Re: Cliff Island Planting- Completion

The photographs are below for the final implementation of the Restoration Plan for 87 Church Road, Cliff Island. Please let me know if there are any additional questions, as this is now fully completed.

SITE MAP
(REFERENCE FOR RESTORATION PLAN)

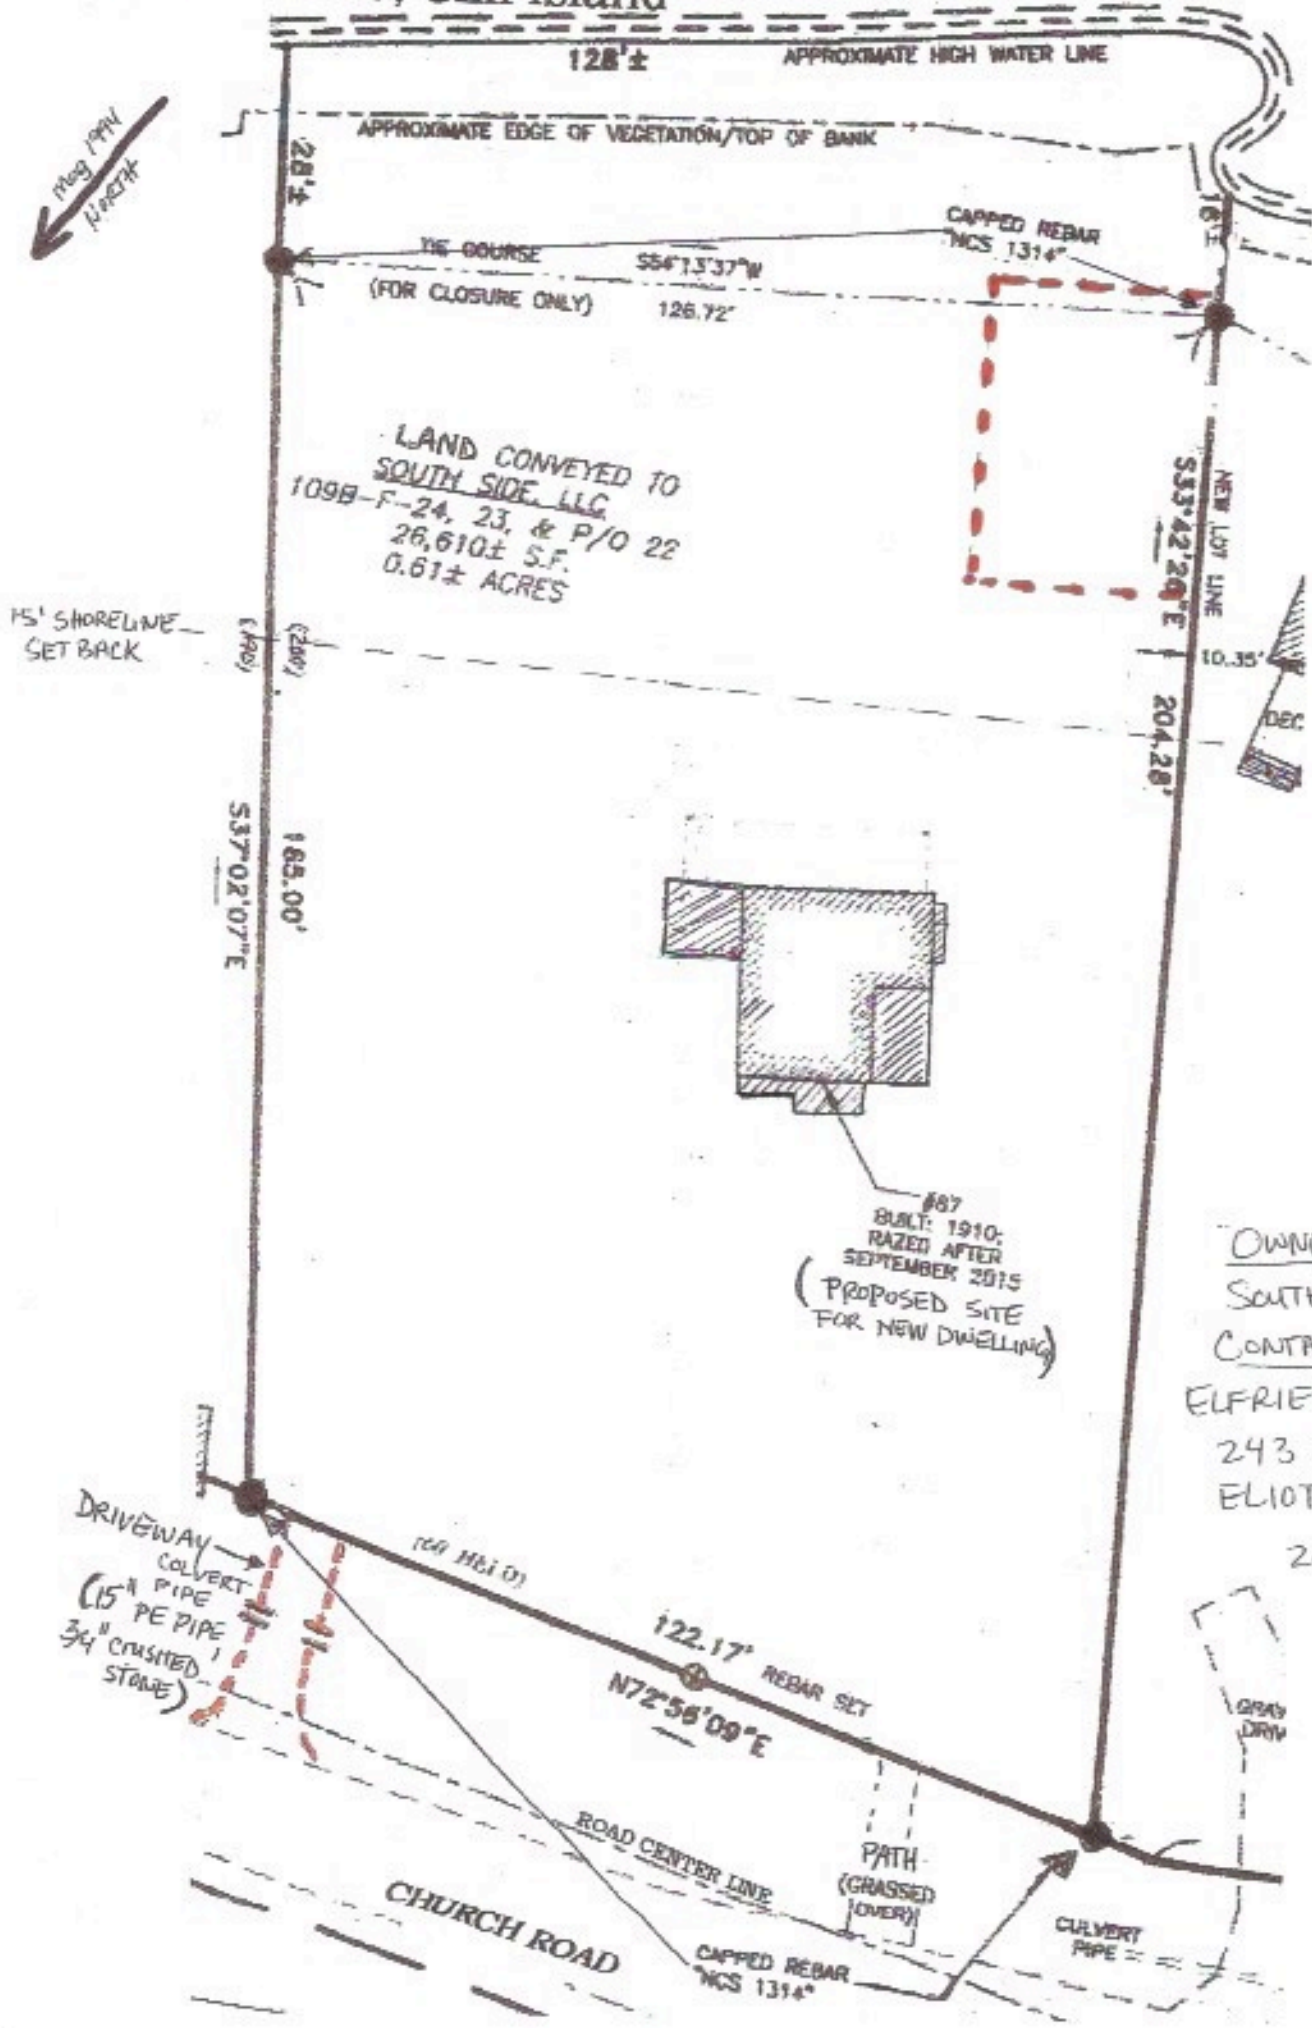
Thanks - I wasn't sure where the invasive plants were removed from.

It is important to note the number of plants removed & location on one sheet and what you plan to replace on the second sheet. On the second sheet with the new plant names the number of plants with the size of plants proposed.
We recommend 2 gallon size minimum.

Hello Jeff,
ACE removed a massive growth of invasive honeysuckle, I cannot determine number of individual plants. Per email from Ann Machado, an area of 1200sf is to be restored. Attached, I have designated the area where the honeysuckle was located, on the first page. The second page, was/is color coded with shape icons to show what we have already planted, and what is intended/proposed to be planted. ALL are described in the Legend (right side). I have now added the required 2 gallon reference for each proposed plant, and the numbers of each variety in the Legend, as well.
Is this sufficient?
Thank you for your help.
Sincerely,
Elfriede Walden

RESTORATION PLAN

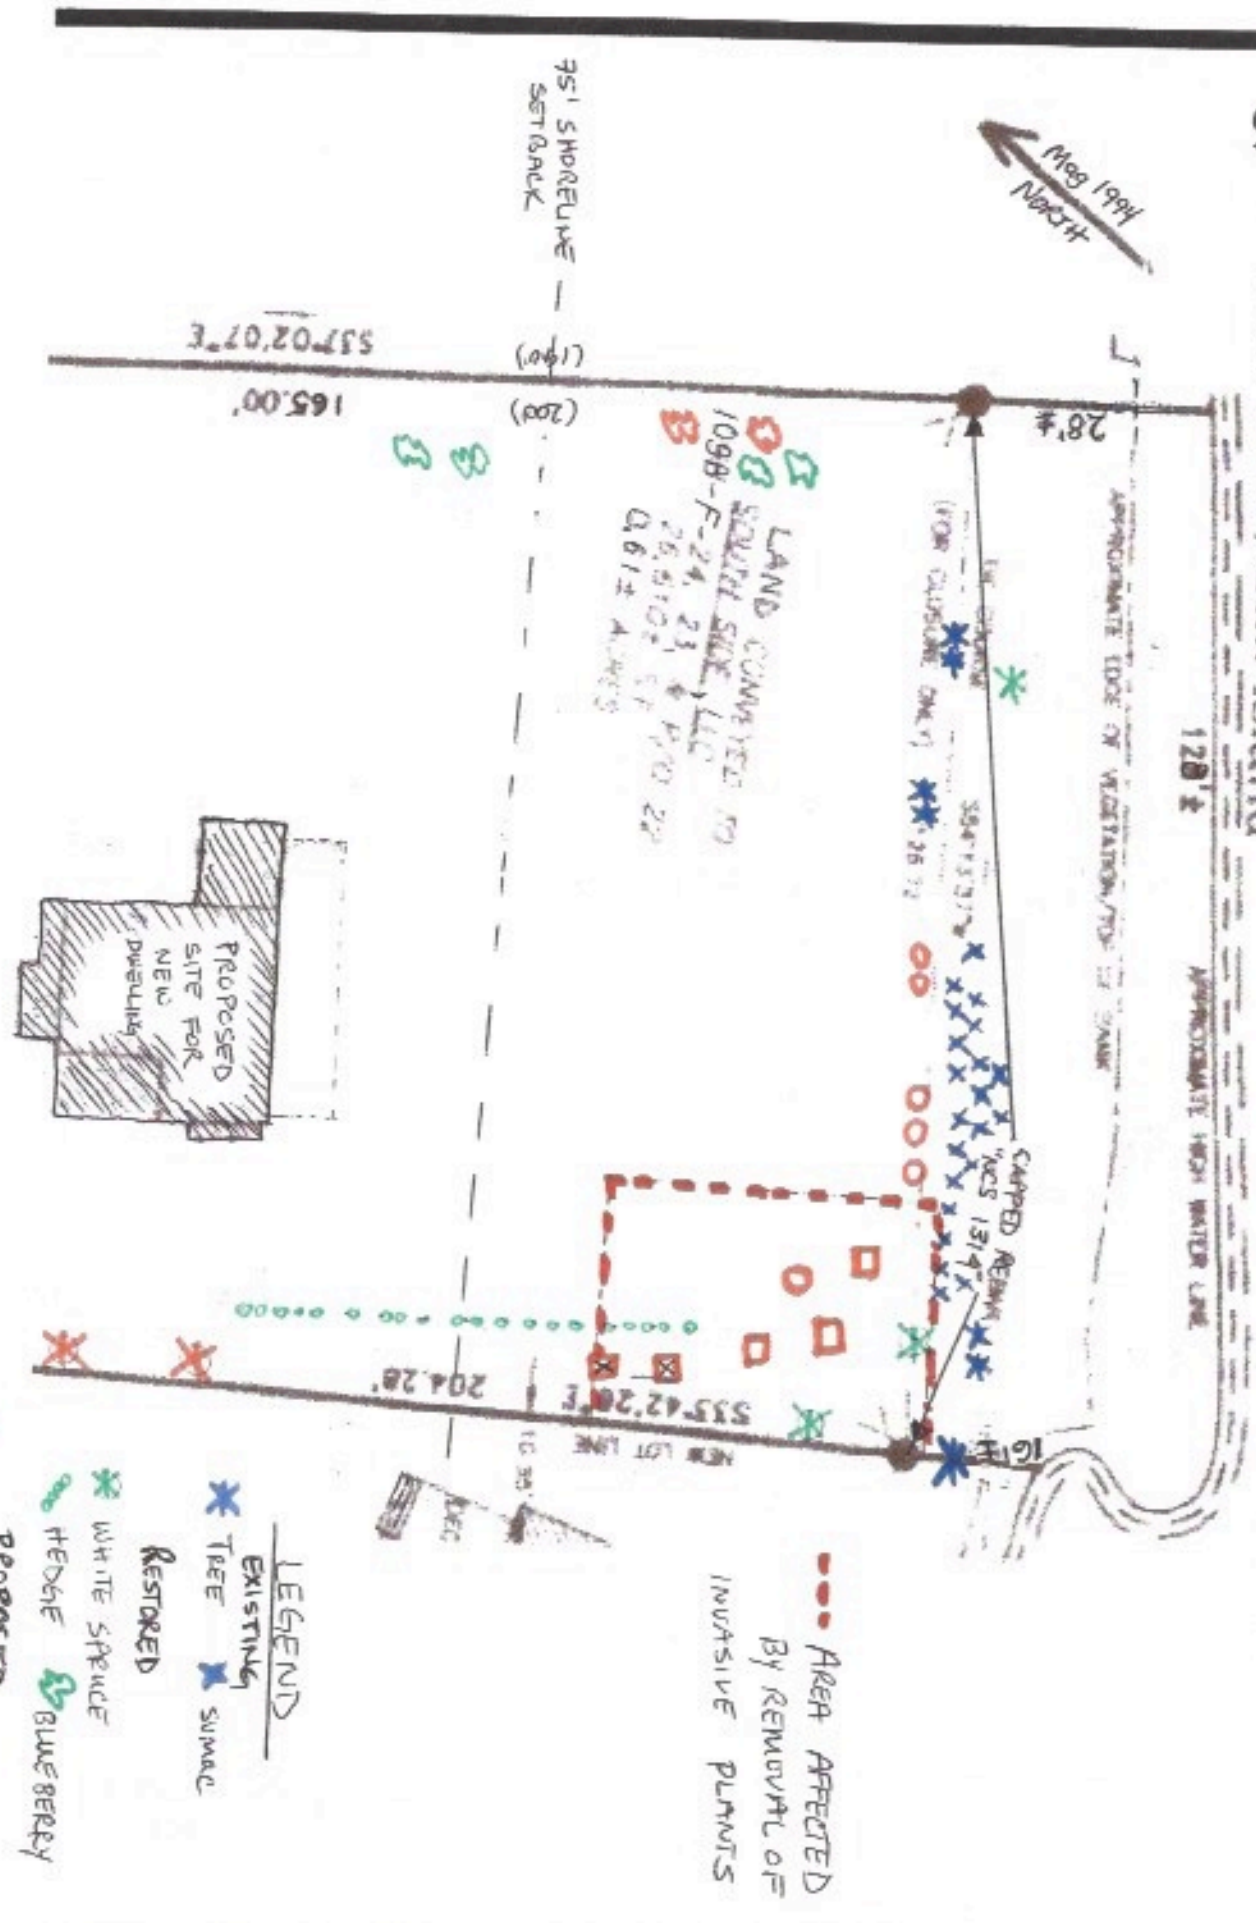
It looks like 6 plants are going back into the red box where the Honeysuckle was removed?

A total of thirteen (13) plants are within the affected area...Two (2) White Spruce were planted already, as well as, Five (5) hedge plants. Three (3) Northern Bayberry, Two (2) Winterberry, and

One (1) Beach Plum are the additional proposed plants to be planted within the affected area. Based on spacing and growth of each variety, additional plants are outside the area in close vicinity. (five (5) additional Beach Plums.
